# Planning Services Sign Permit Review Form

Date of Submittal	Application Number	Applicant	Landowner
2/2/2022	SIGN2202-0003	ASI Signage	Development By The Numbers Inc.

Contact Person	Contact Number
Heather Spray	(919) 346-0283
Sign Location	PIN Number
Purfoy Road & Lambert Lane	0664-48-6617.000

C 1.1
DRAWN BY: SBT CHECKED BY: SBT

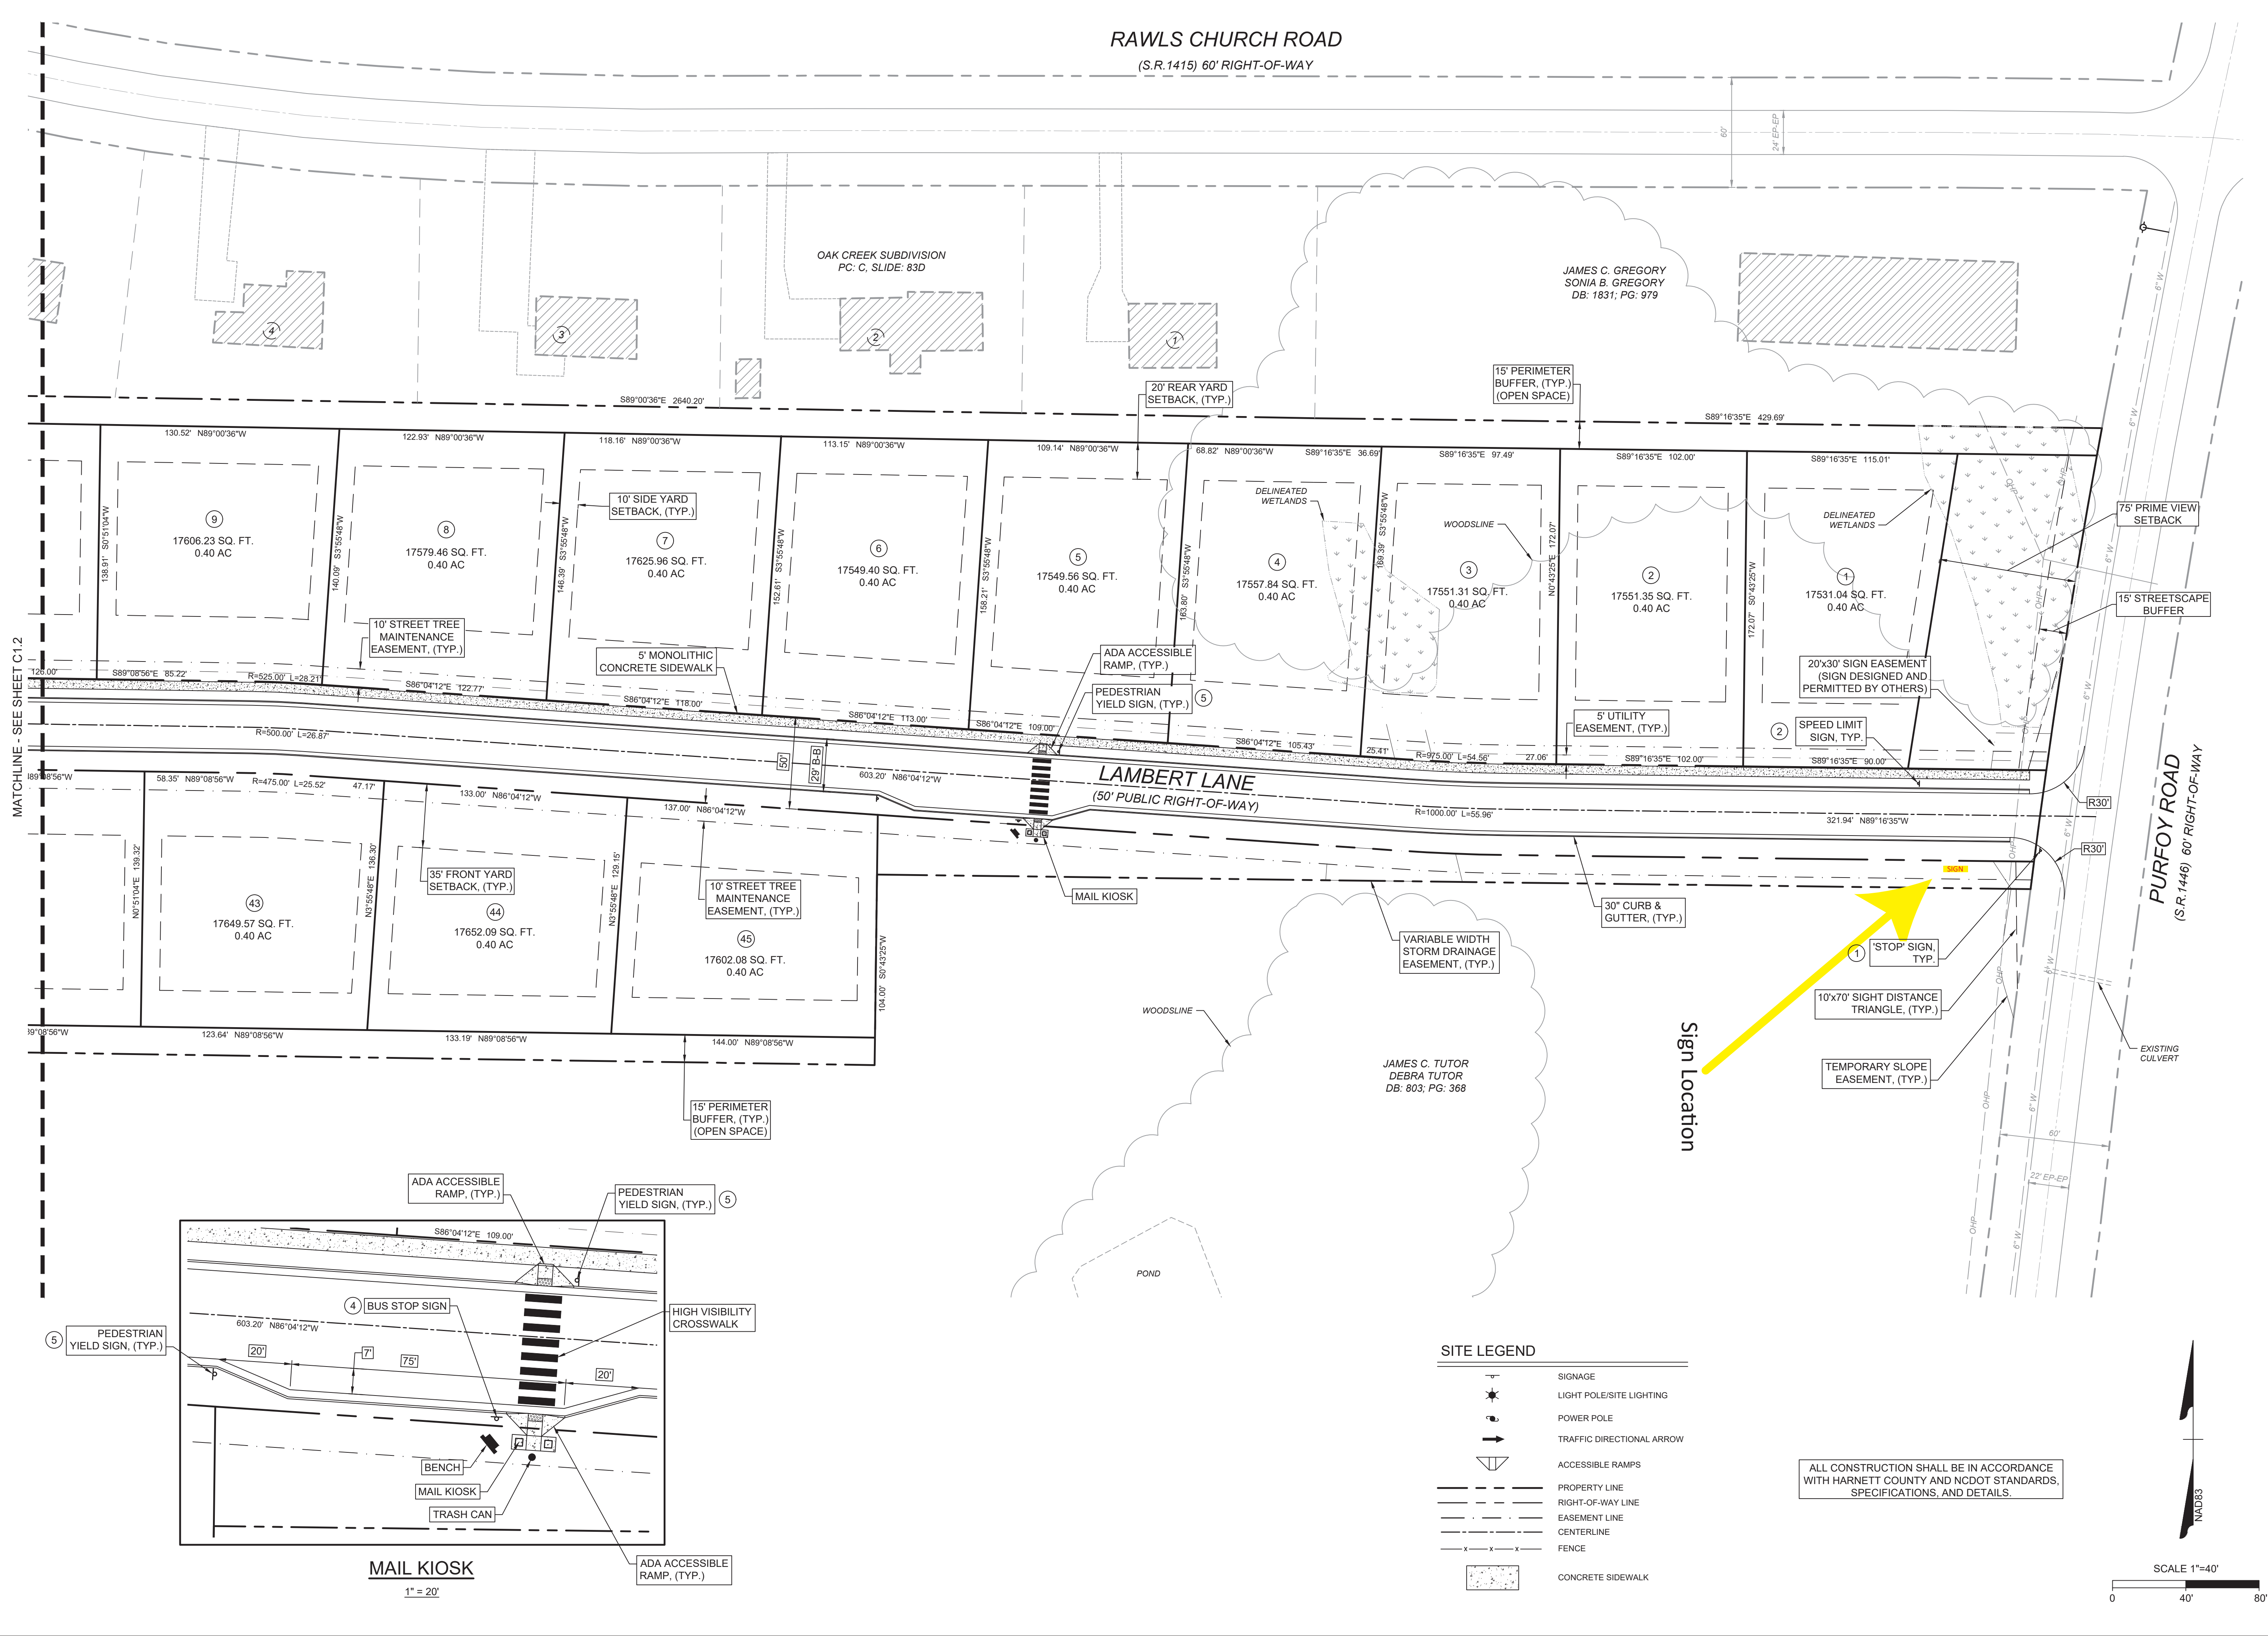
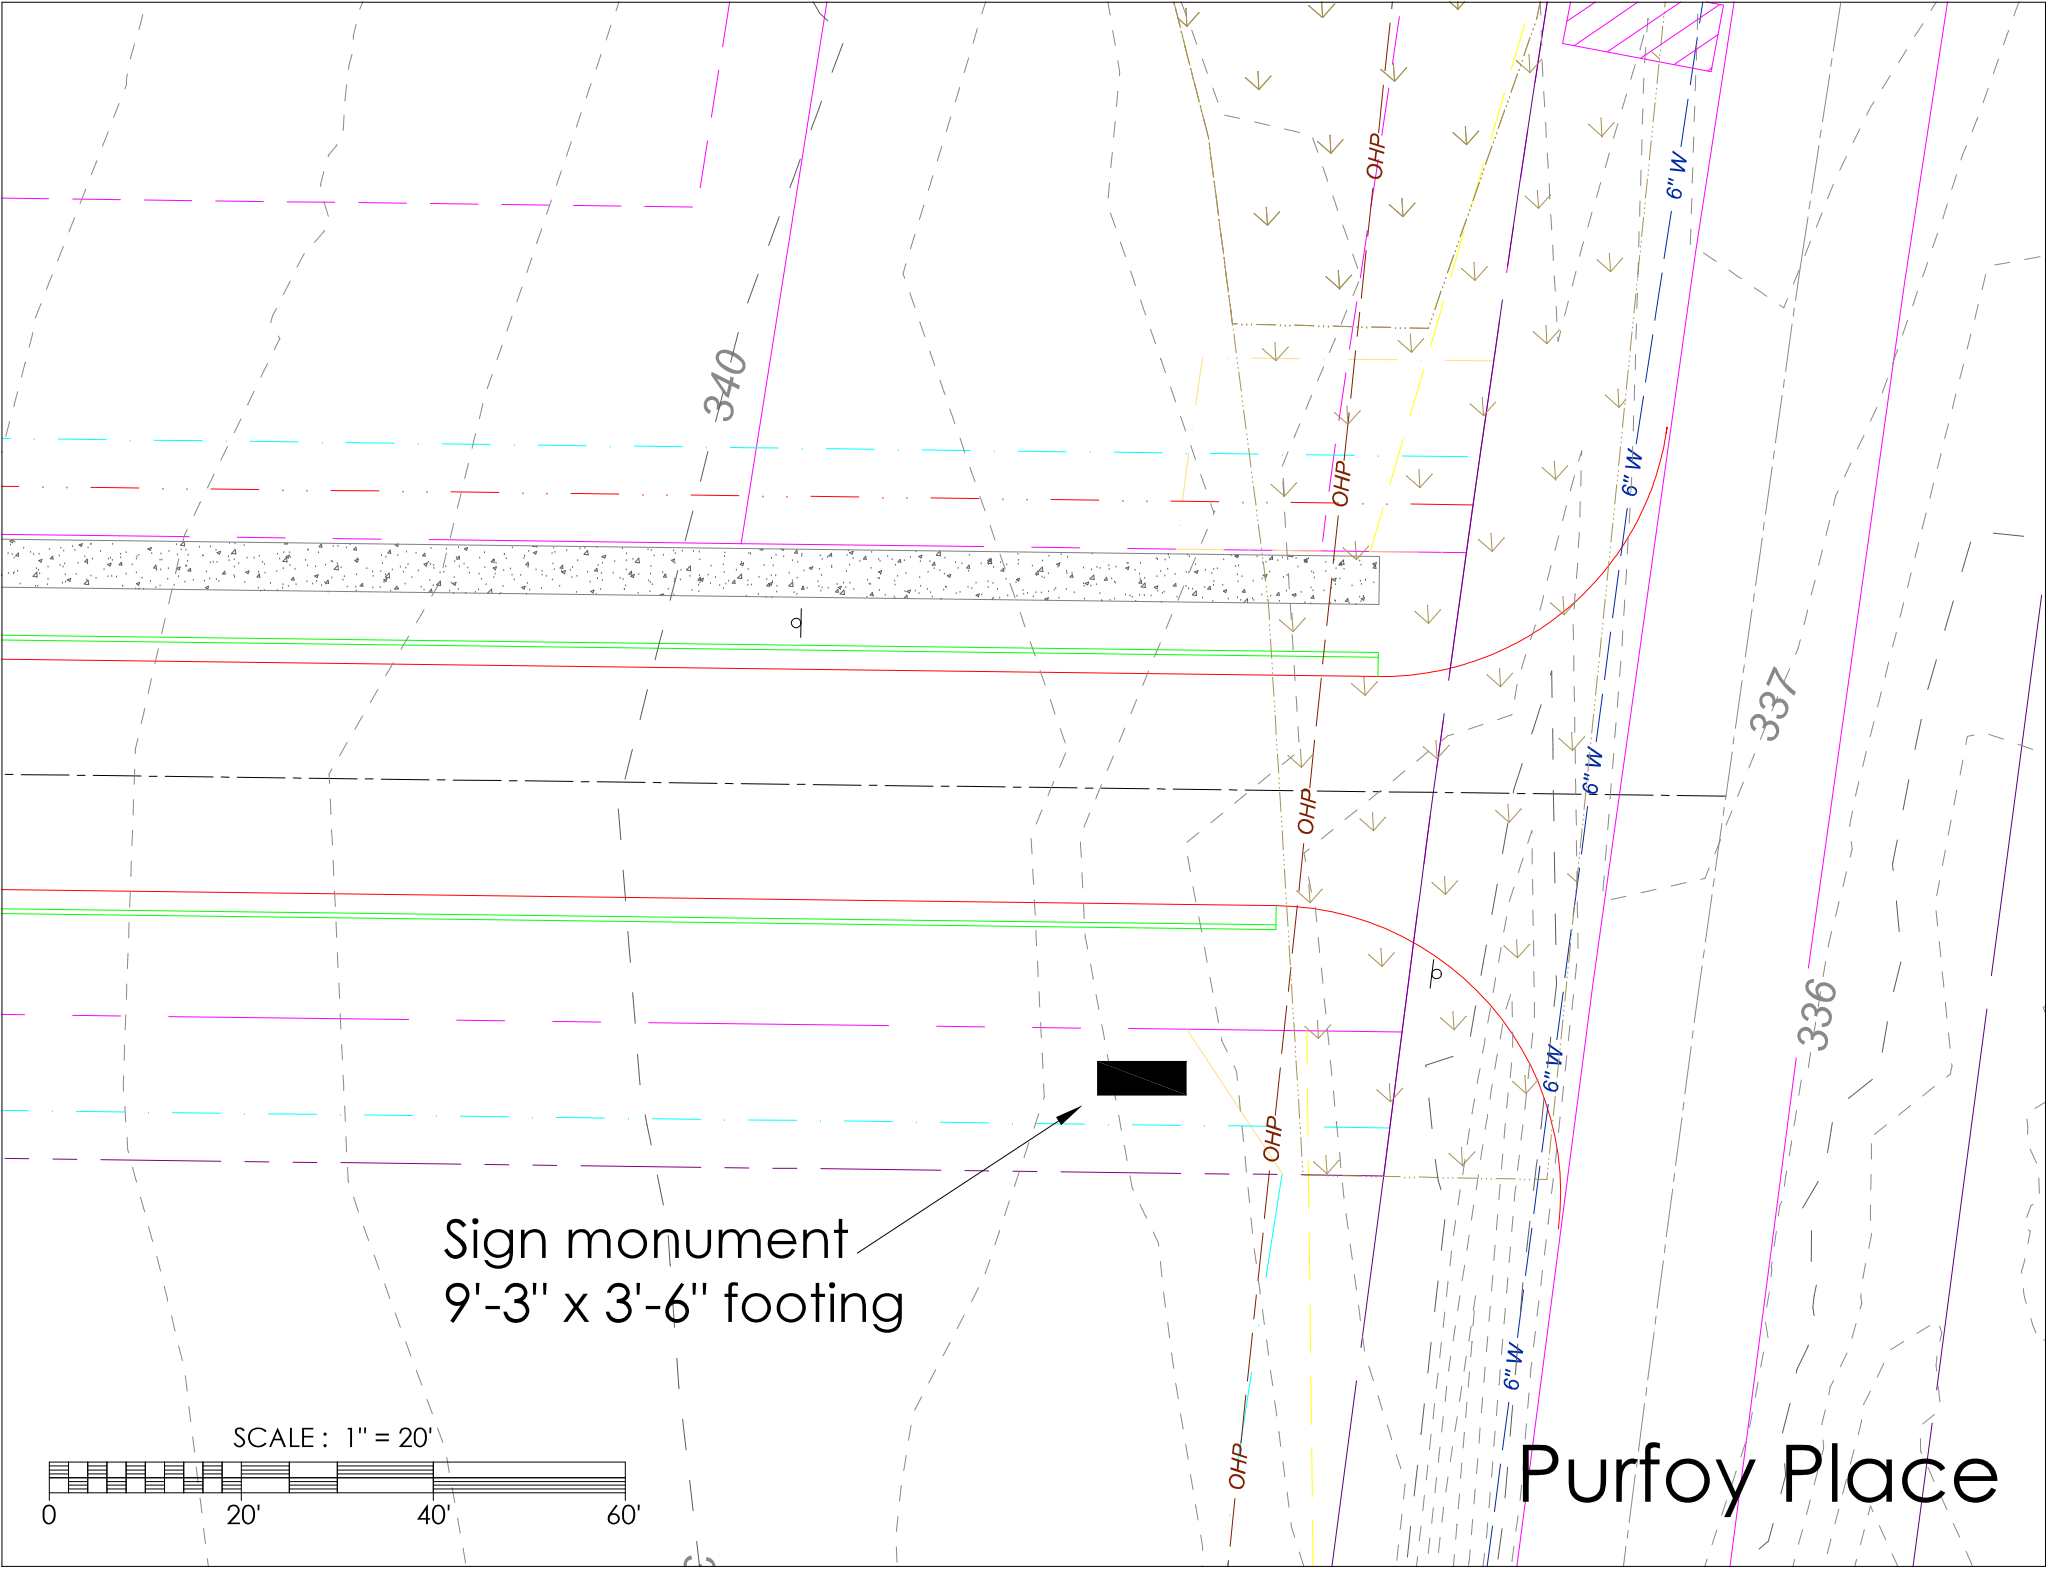
Comments	Need site plan that illustrates the distances from the right of way of both Purfoy & Lambert. Submitted location will not provide sufficient space for placement of proposed signage.
----------	---
